Independent Technical Review

Kariong Sand and Soil Supplies Facility - Air Quality Impact Assessment

Prepared for Department of Planning, Industry and Environment
May 2021

J210264 RP1

Figure 2: AERMET generated windrose

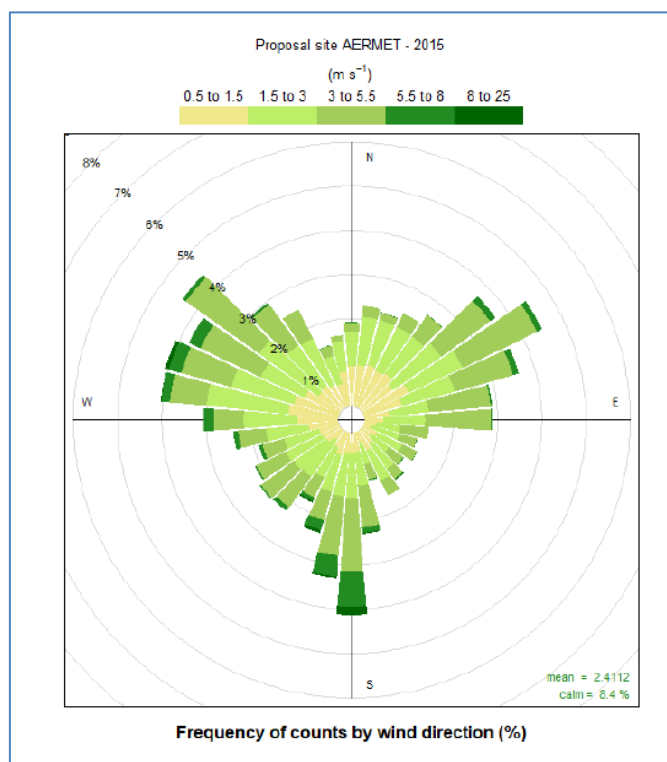
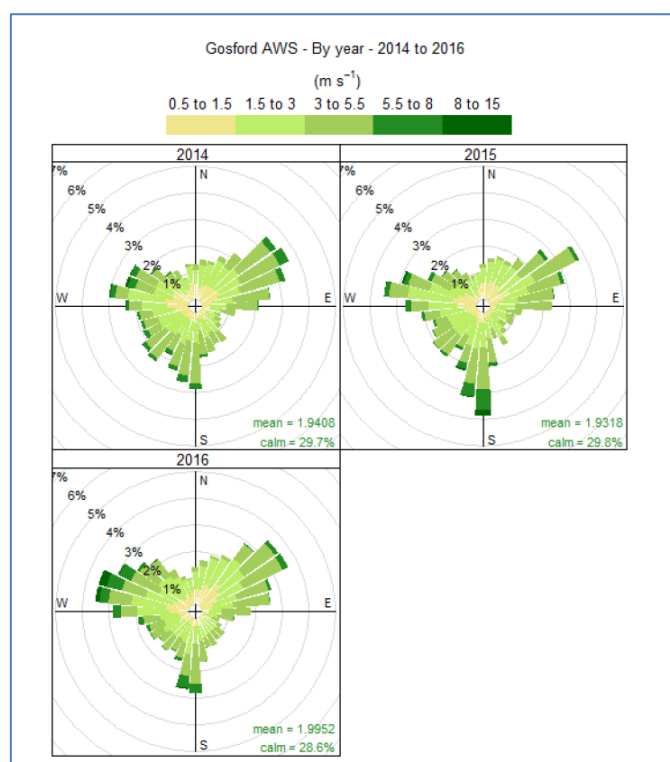
Similarly, the TAS peer review of the RtS (11 March 2021) contents that low wind speed conditions are excluded by the selection of the Gosford data. This statement from TAS also appears to be misleading, as the Gosford AWS data records almost 30% calm wind speed conditions for 2015 (ie less than 0.5 m/s). However, although not discussed in the TAS peer review, the AERMET generated wind rose for the project site records significantly lower calm wind conditions (8.4%) compared to the Gosford AWS input data (29.8%) and higher annual average wind speeds (2.4 m/s) compared to the Gosford AWS input data (1.9 m/s) (discussed further in Section 4).

Based on information provided in Table B2 of the revised AQIA, Northstar's have used data from the Williamtown RAAF BoM station as input to the 'surface station' and 'upper air' pathways and data from Gosford AWS for input to the 'onsite' pathway. The AERMET pre-processor merges data from the surface and onsite pathways to produce a single AERMOD ready meteorological input file. As mentioned previously, this is the likely reason for why the

AERMET generated wind rose for the project site records significantly lower calm wind conditions (8.4%) compared to the Gosford AWS input data (29.8%) and higher annual average wind speeds (2.4 m/s) compared to the Gosford AWS input data (1.9 m/s).

However, it is difficult to determine whether this reduction in calm winds and generally higher wind speeds is representative of the project site, as there are no local data against which a comparison can be made. This is the crux of the argument, although there is general agreement about the uncertainty of the meteorological input data. The point of difference is that the TAS peer review believes the approach is unacceptable as it will lead to underestimation of impacts based on the assertion that the project site would experience lower winds speeds (ie poorer dispersion conditions) and more westerly winds (ie blowing towards receptors) than what was modelled.

EMM agrees that there is uncertainty in the use of meteorological input data, however we cannot substantiate the claim that the project site would experience lower winds speeds and more westerly winds than what was modelled.

While some uncertainty remains in the meteorological inputs and approach to the air quality modelling, EMM agrees that the proposed approach of design changes, reduced throughput and commitments for site specific meteorological monitoring is a suitable way to circumvent this uncertainty.
